28 July 2016

File No: 2016/401214  
Our Ref: R/2015/18/A

**RE: LEES 1 Science Research and Teaching Facility (SSD 7054) and F23 Administration Building (SSD 7055) – The University of Sydney**

2:00 PM - 22 DECEMBER

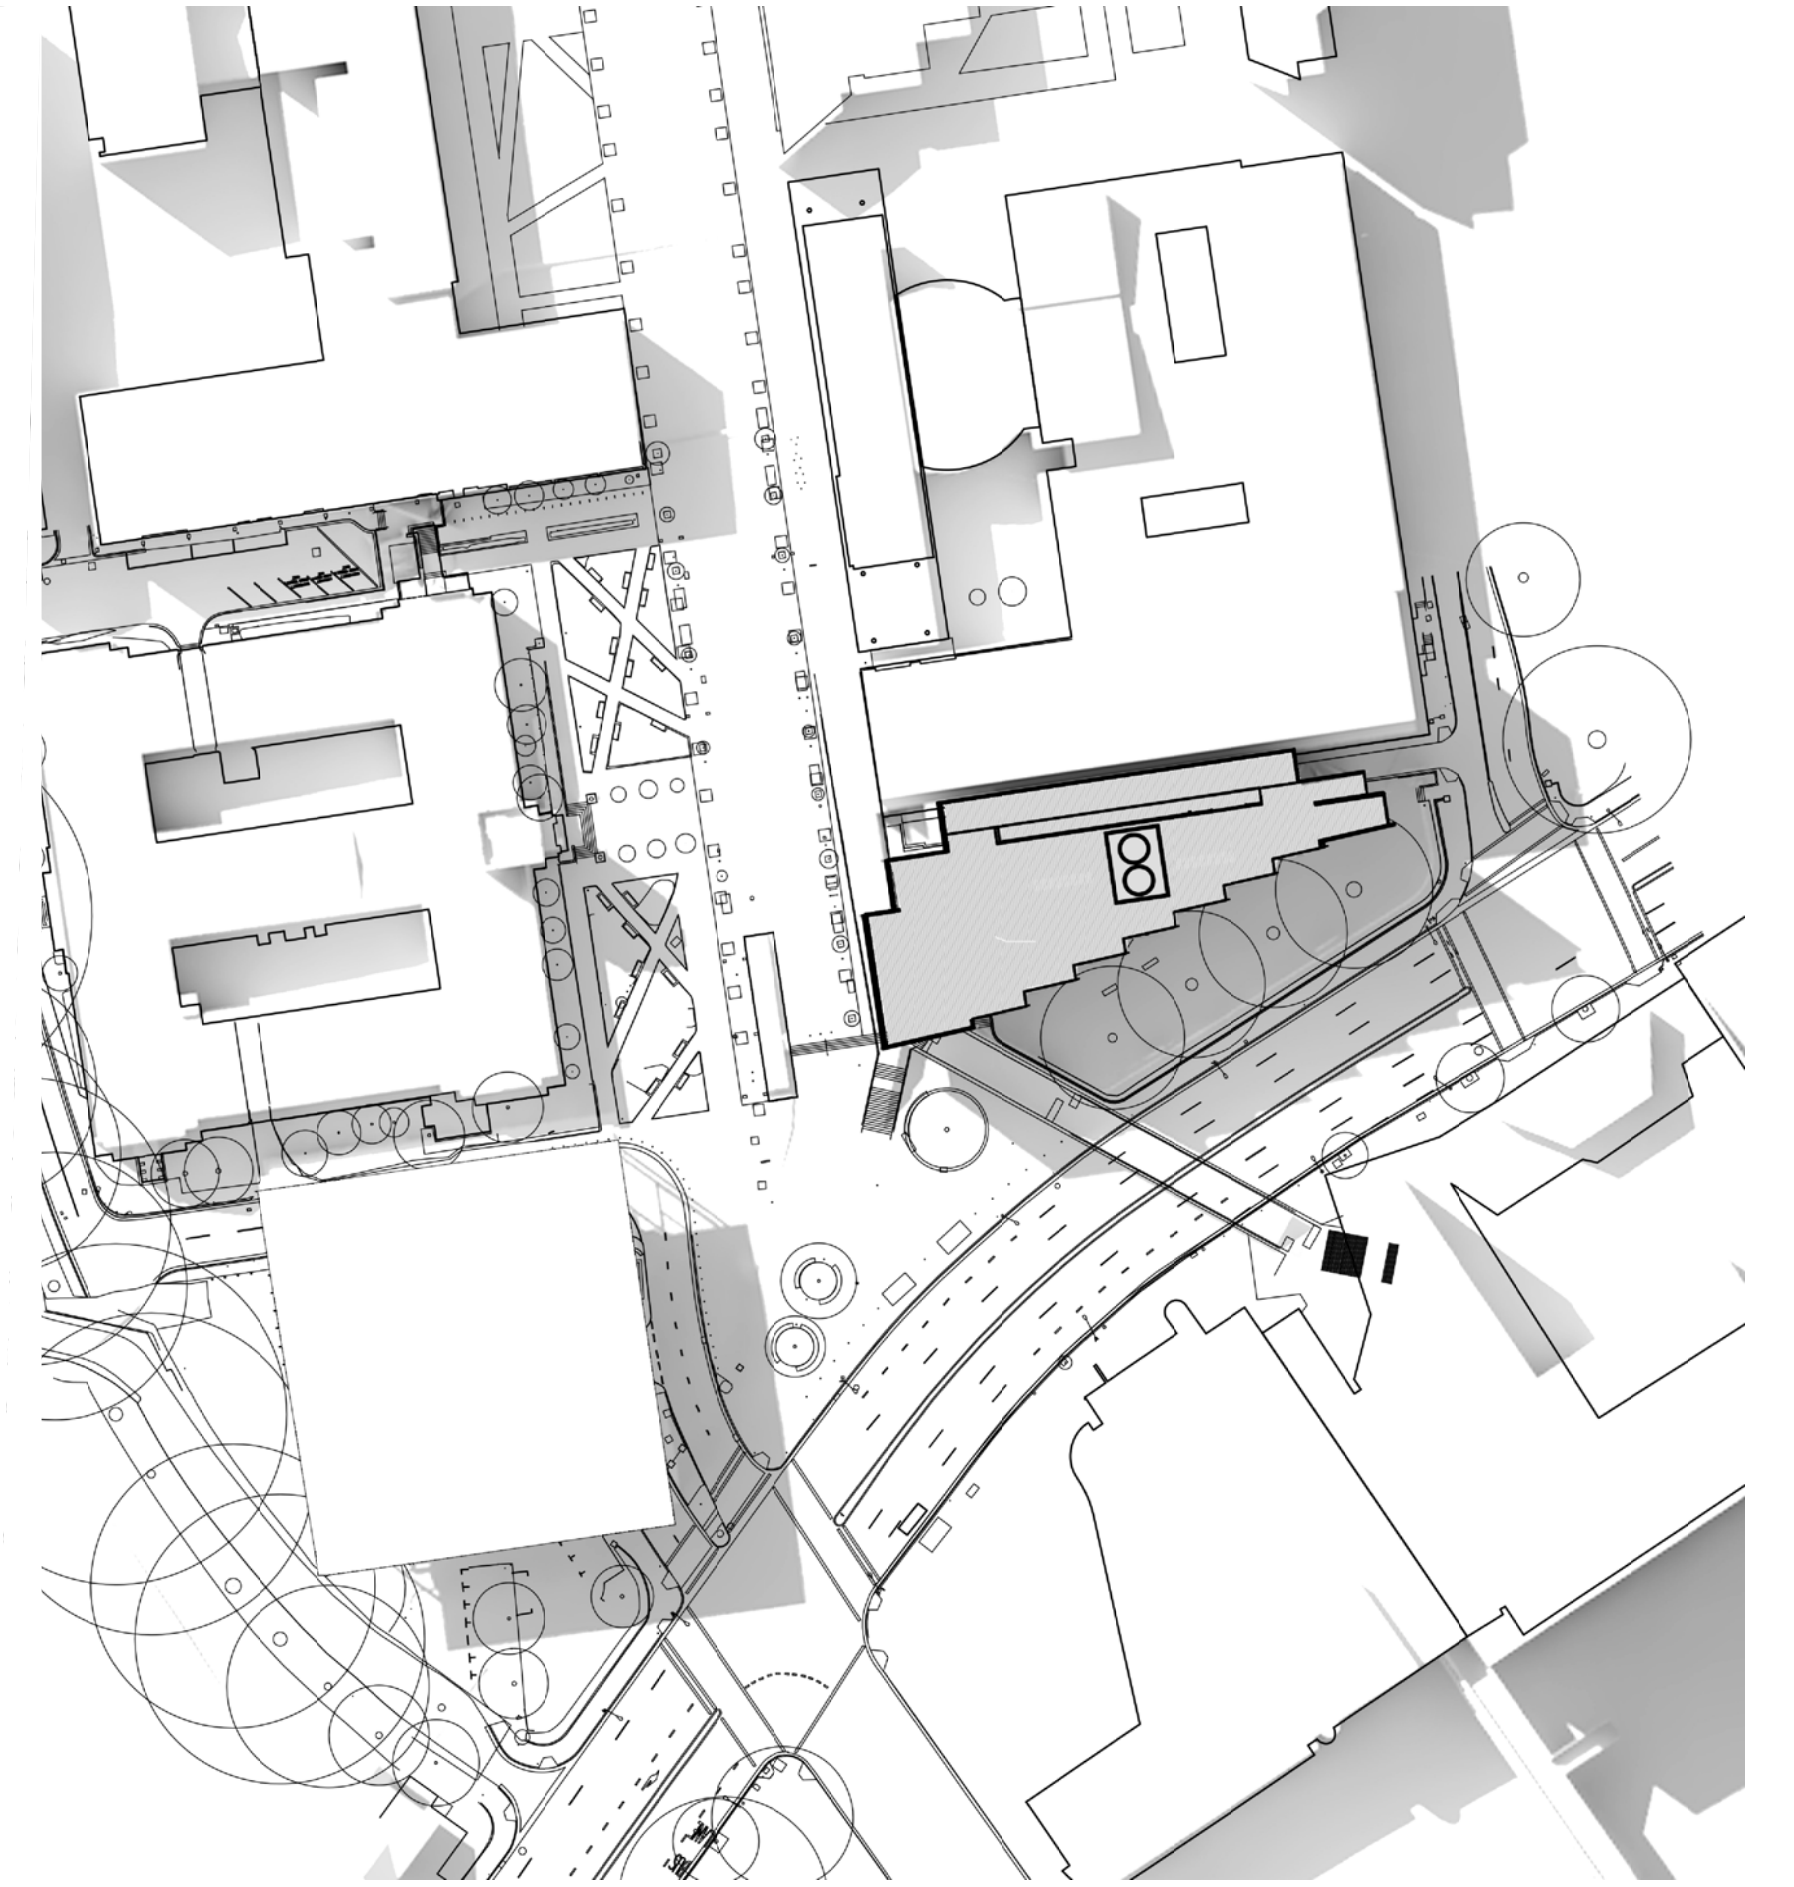
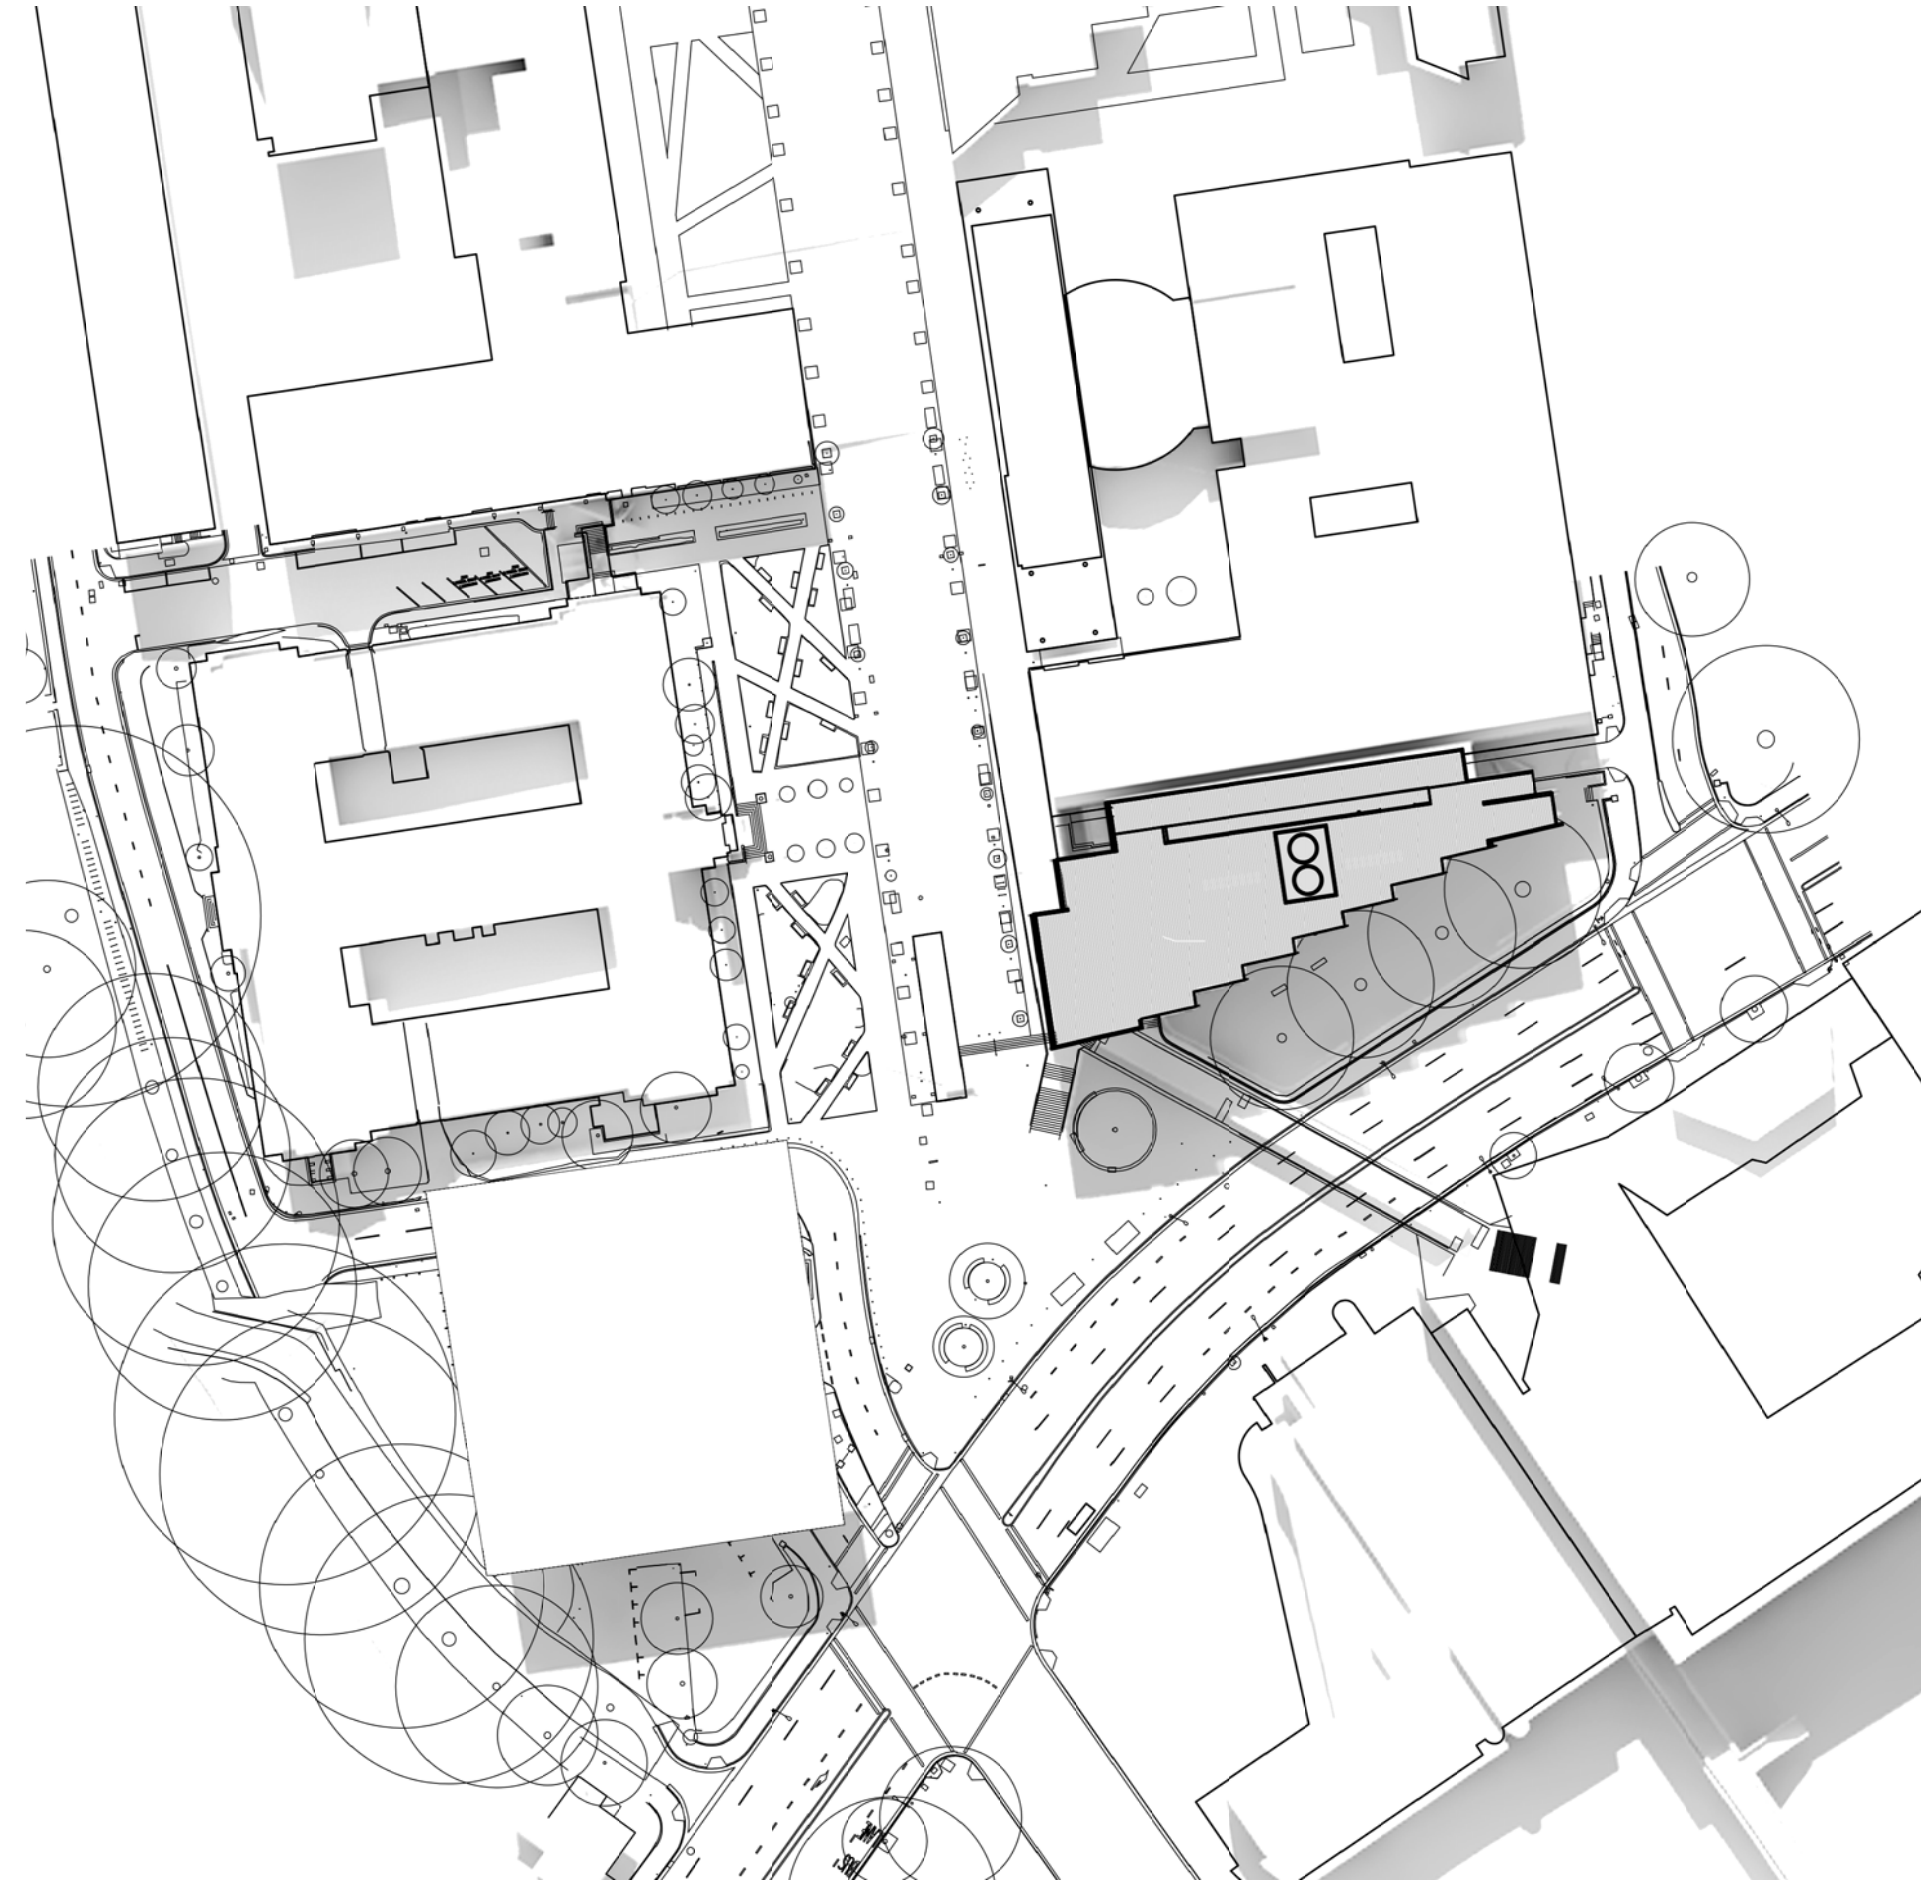
Detailed diagrams are required to differentiate the existing shadow from that of the shadows cast by the proposal. The diagrams illustrate significant overshadowing of the existing (retained) Fig trees along City Road between midday and 3pm. This is likely to result in adverse impacts upon tree health and longevity.

Shadow impacts upon the Sydney University Building on the southern side of City Road are also indicated in the drawings. The extent of this overshadowing is unclear.
